About the application

Application number: 2020/90367	
What is the application for?:	Outline application for part demolition of existing building and erection of deta
Address of the site or building:	adj, 111, Marsh Lane, Shepley, Huddersfield, HD8 8AS
Postcode:	HD8 8AS

Type of comment: An objection

title outline sketch plan proposal
number 19084D-02-P04
scale 1:200
size A1

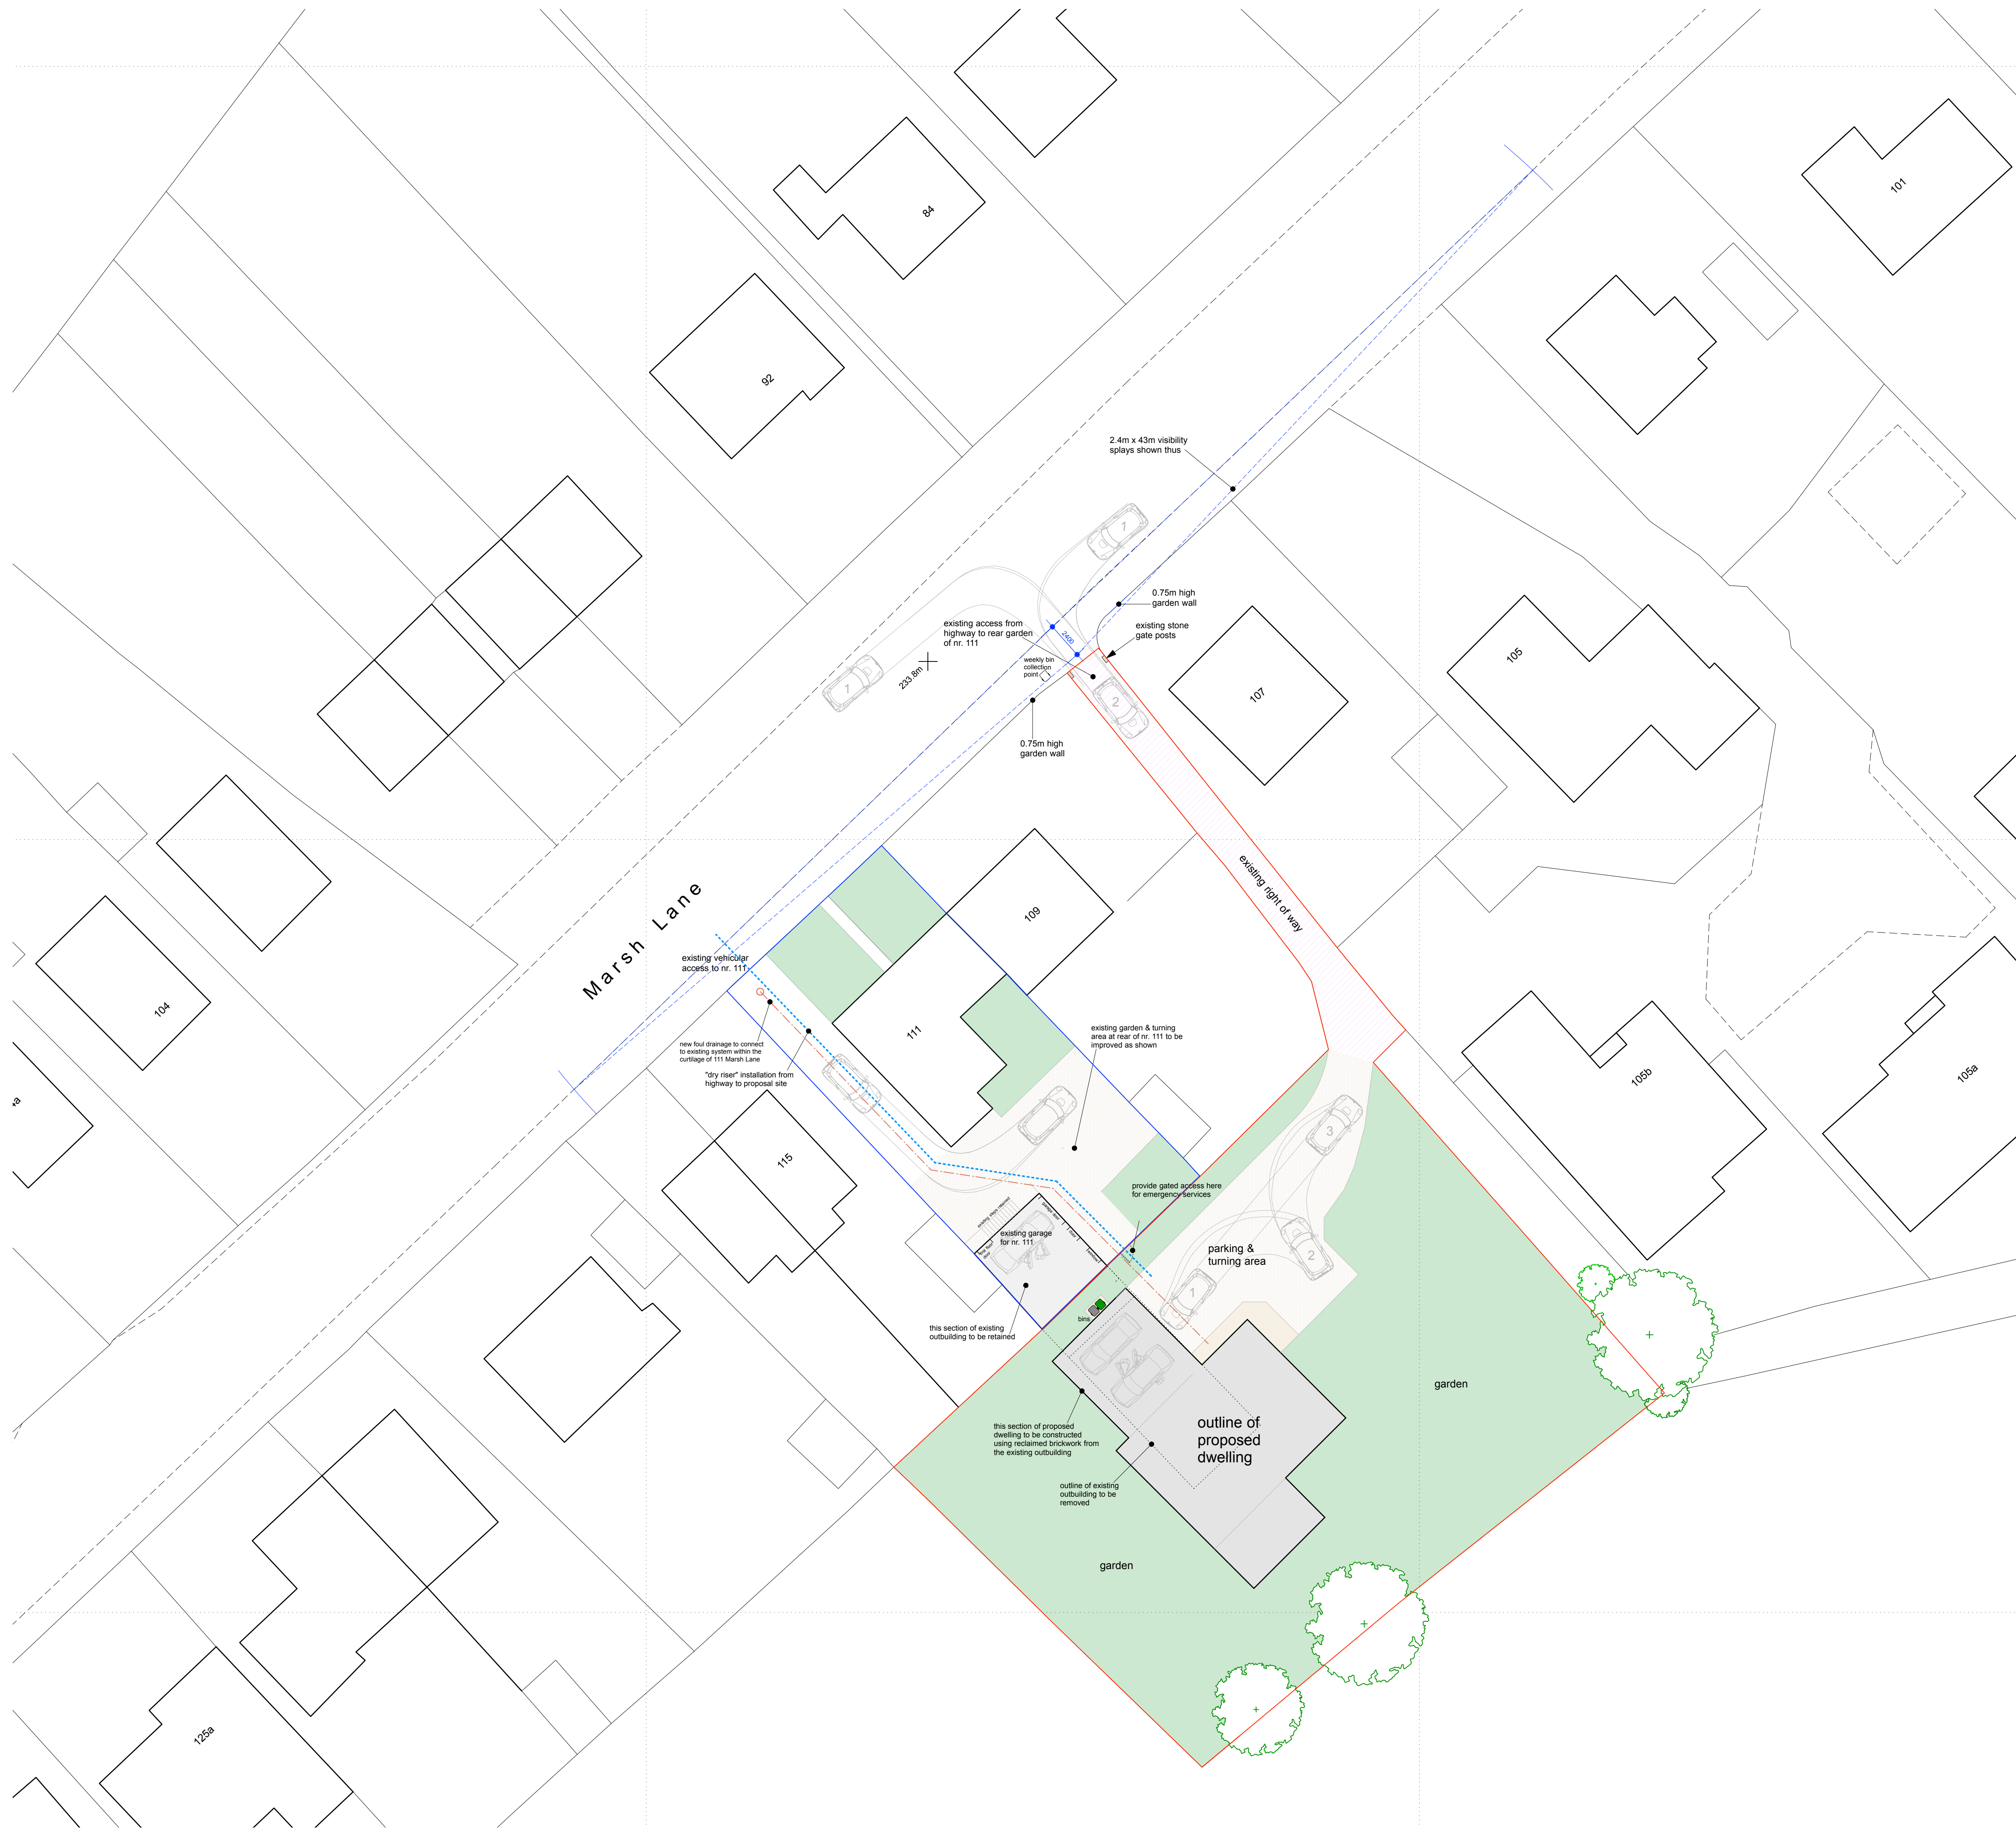
The proposed access points at the side of 109 Marsh Lane and also along the existing driveway at 111 are too narrow and therefore not suitable for any large or emergency vehicles such as fire engines. The only way to get any large vehicle through would be to demolish an historic building - see below.

There are currently no houses at the rear of Nos. 111 to 127 Marsh Lane. The proposed 4+ bedroom house at the rear of 111 Marsh Lane would overlook all of these properties and lead to a loss of privacy. I am concerned particularly for my father's house at Marsh Lane, which is a and would be potentially dwarfed by the new build house at the rear of 111. The proposed orientation of the new house would mean that

The proposed house also seems too close to existing houses.
